Hinckley National Rail Freight Interchange

Burbage Deadline 3 – Response

Burbage Parish Council Written Presentation

Drawing file: TR050007 / TR050007-002126-18.18 Hinckley NRFI M1 J21 Modelling Note (Appendices).pdf

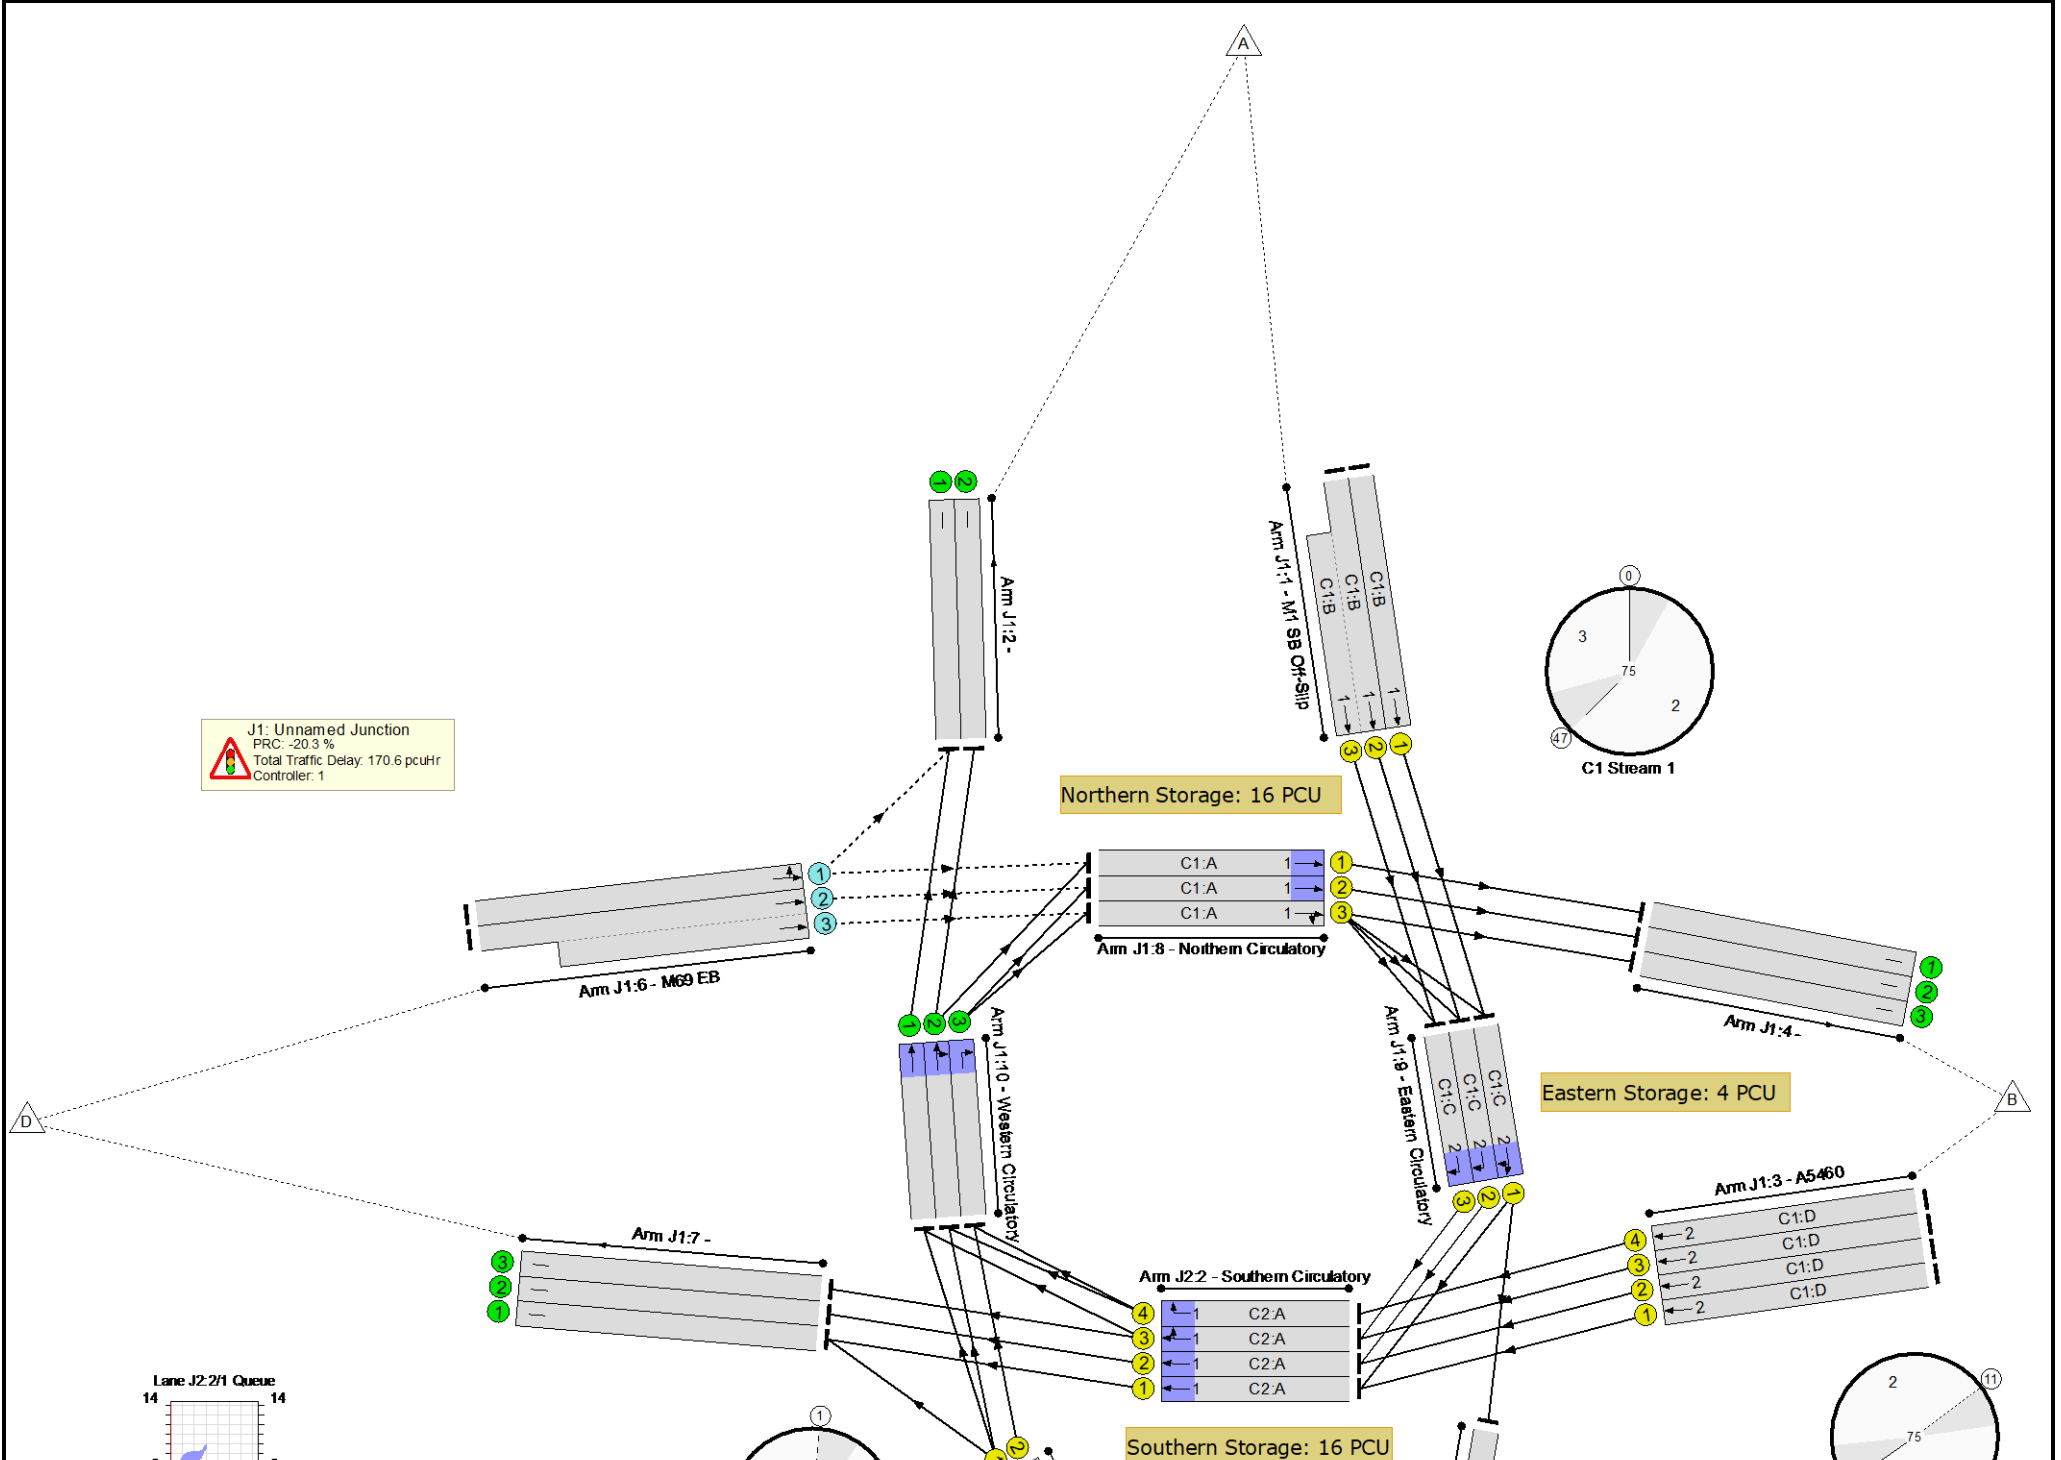
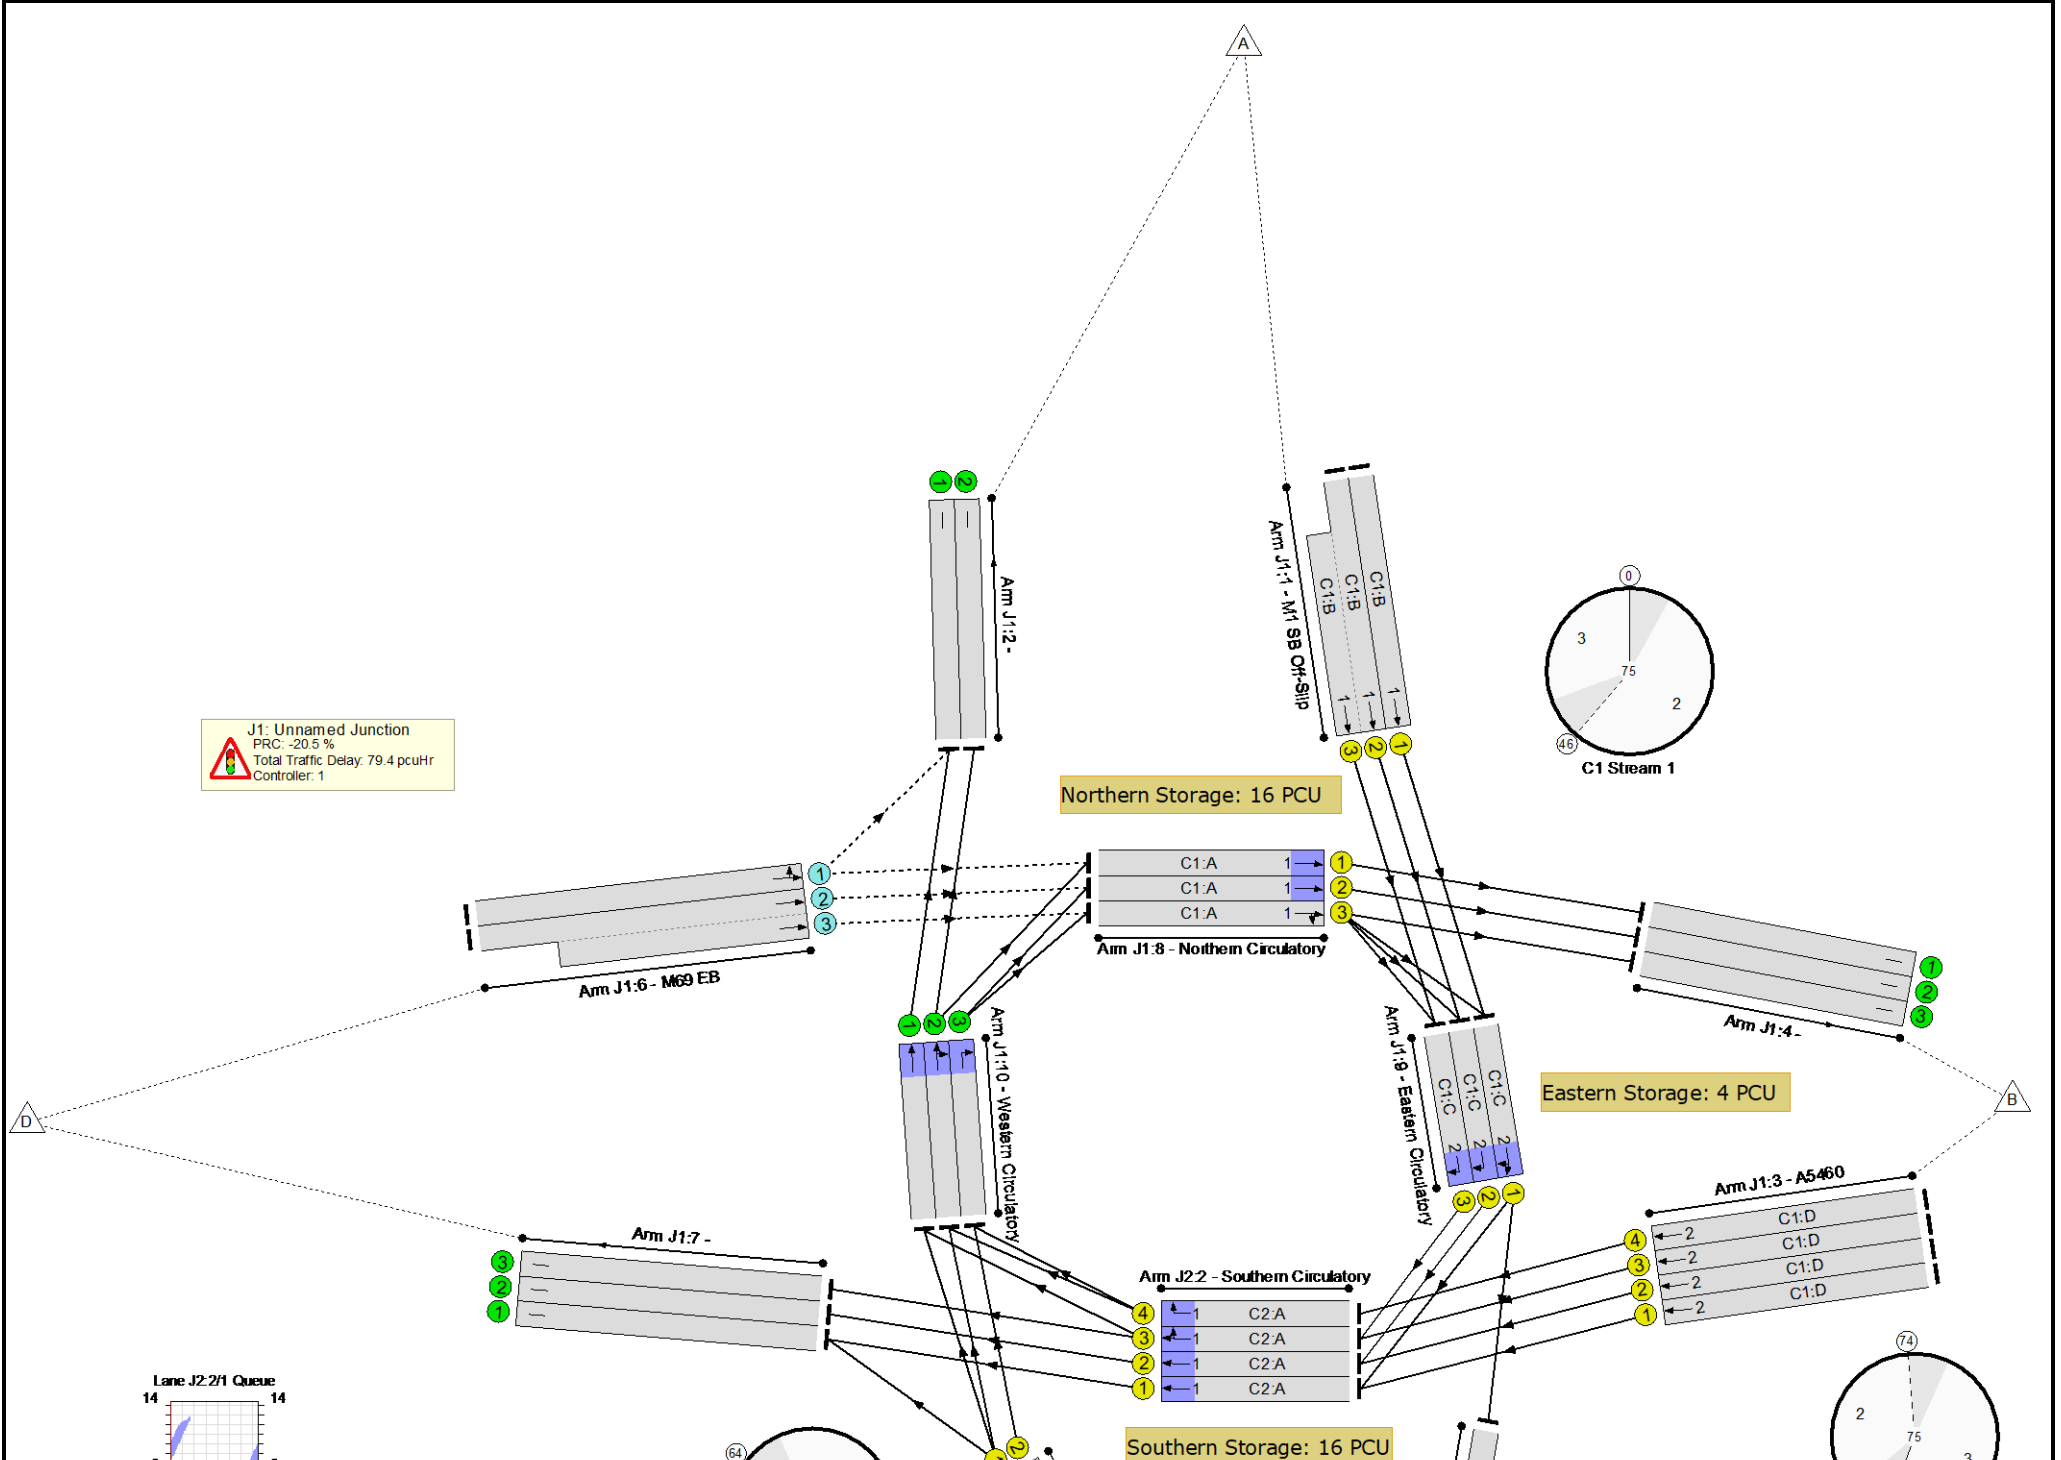
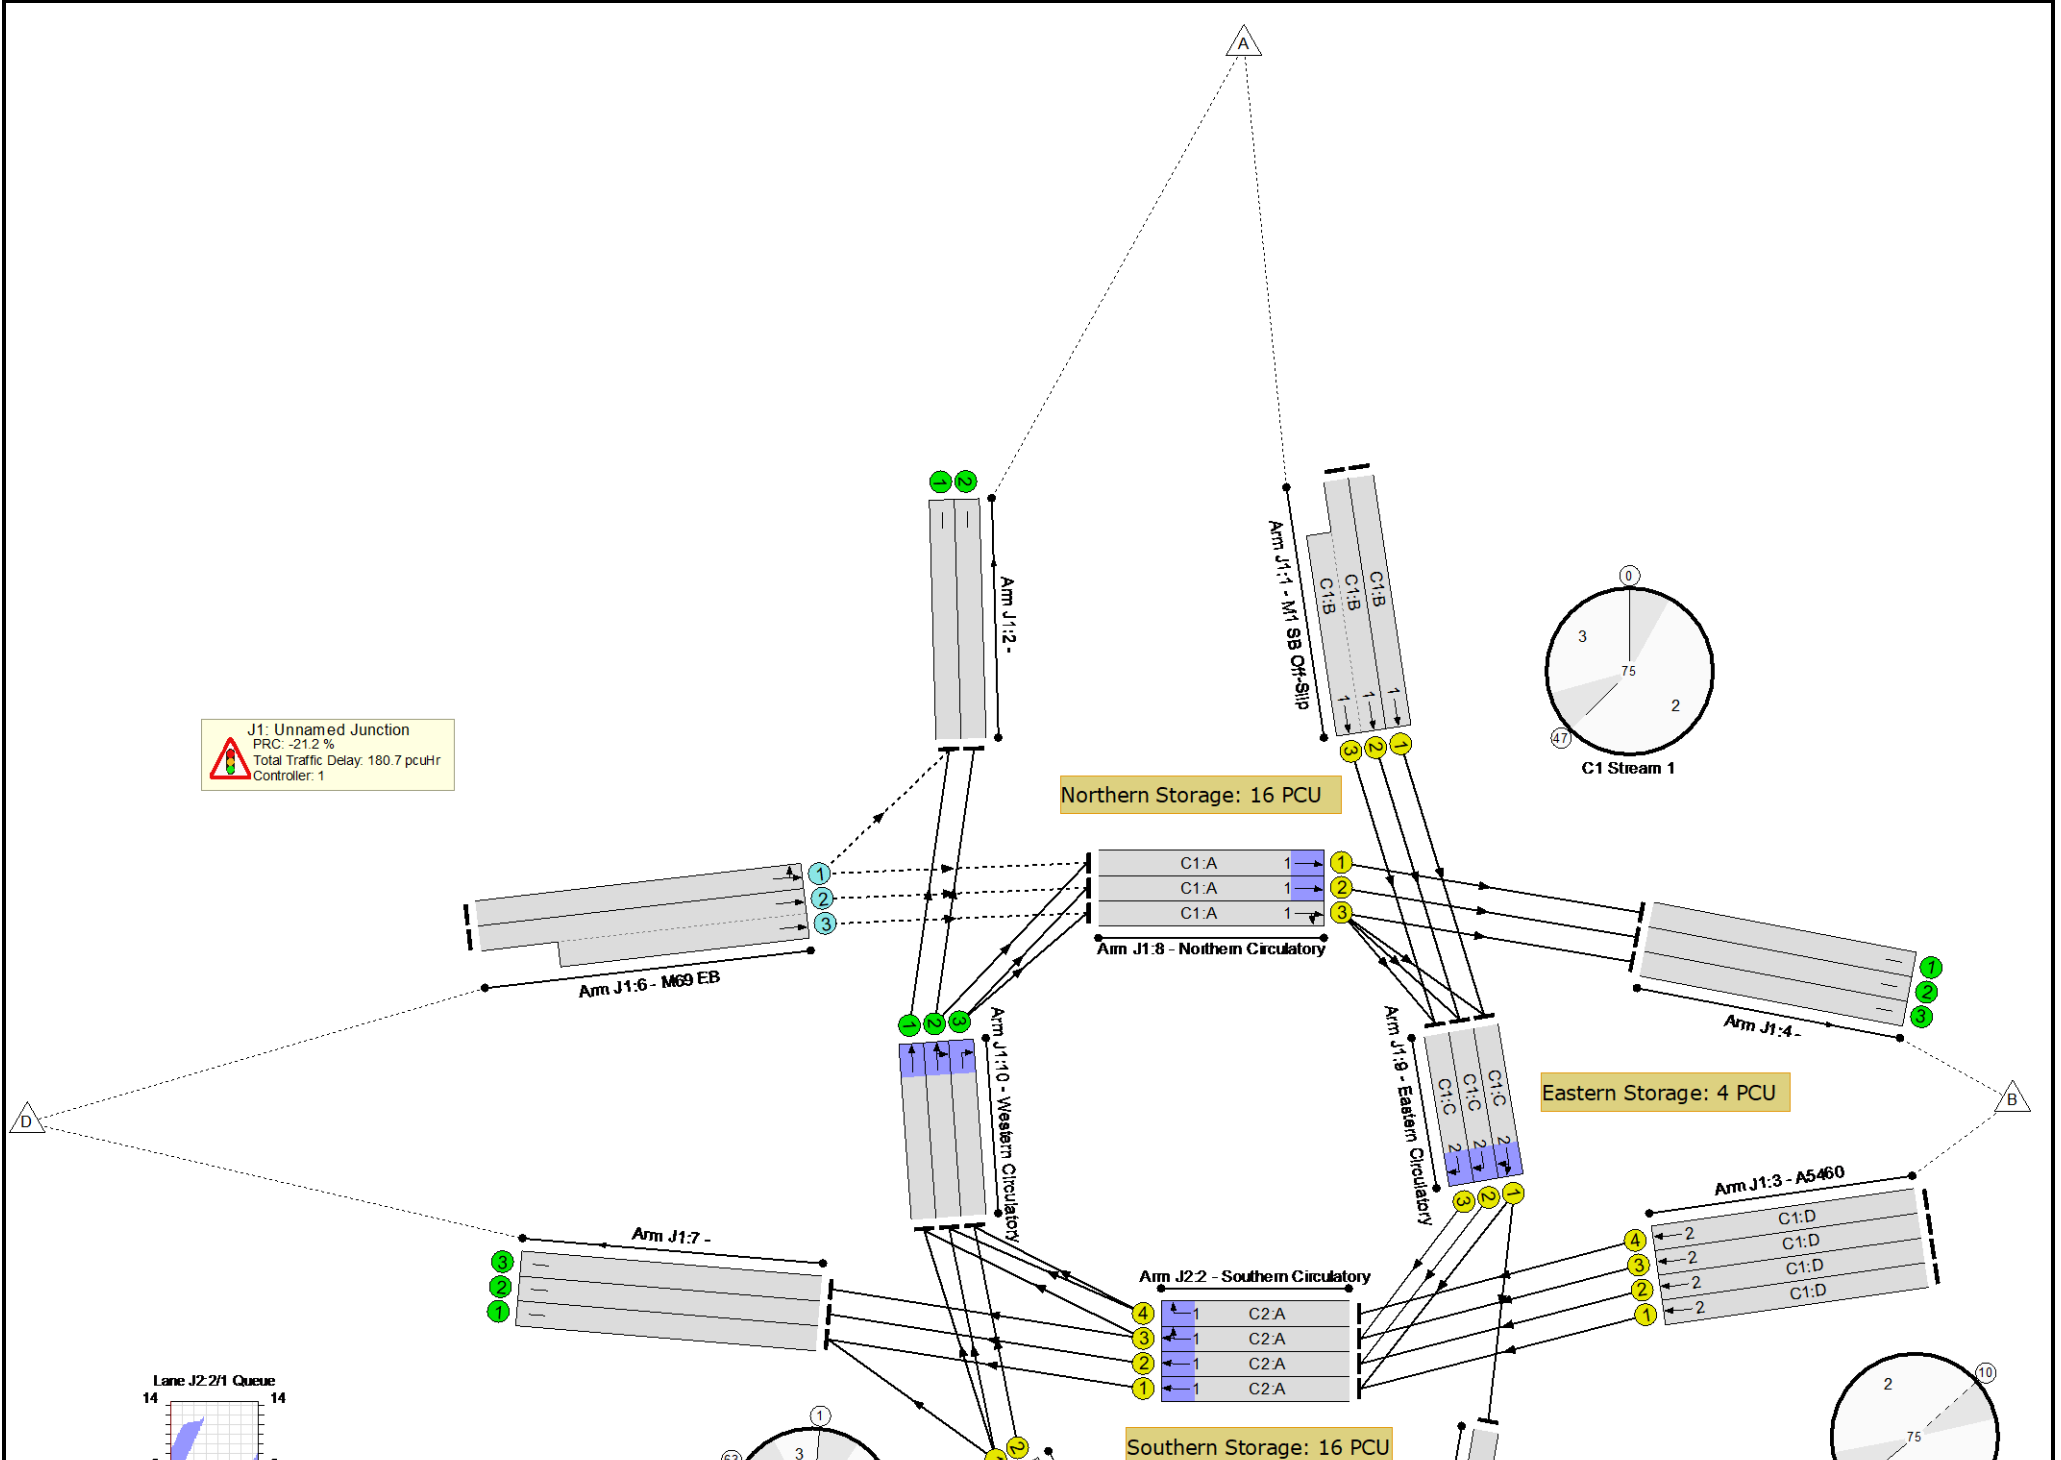
M1 Junction 21/ M69 Junction 3

We were appalled to hear at ISH2 that Tritax Symmetry have taken the view that they do not have to submit **any** mitigations for this junction due to the additional traffic from the development. Our understanding from the hearing was that given the junction is at capacity and that development HGV traffic heading North will be mandated to use the M69 and this junction which will have severe delays, due to operation of the junction above the capacity. The effect in the modelling is that local

traffic (including non-development HGVs) will see extended delays at the junction and will therefore use the local road network to achieve a route into Leicester or the North bound routes.

If our understanding of the discussions at the hearing are correct, this will add a further, previously not discussed, impact on the local road network and the ability of our local community to go about their normal activities.
